Application for a Non-Material Amendment Following a Grant of Planning Permission

Demolition of existing carport, garage, storage buildings and summerhouse and erection of two storey side extension and detached garage

22/1190/HOUS

Additional window and deletion of roof window
Deletion of render to external walls of extension

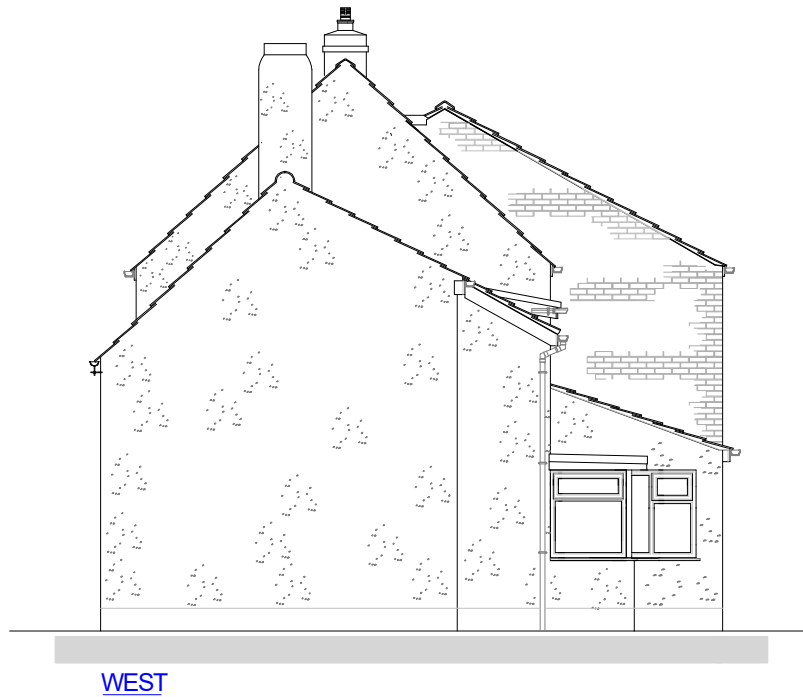
To provide more natural light and improve outlook
Facing brickwork to whole extension more in keeping with the area and building
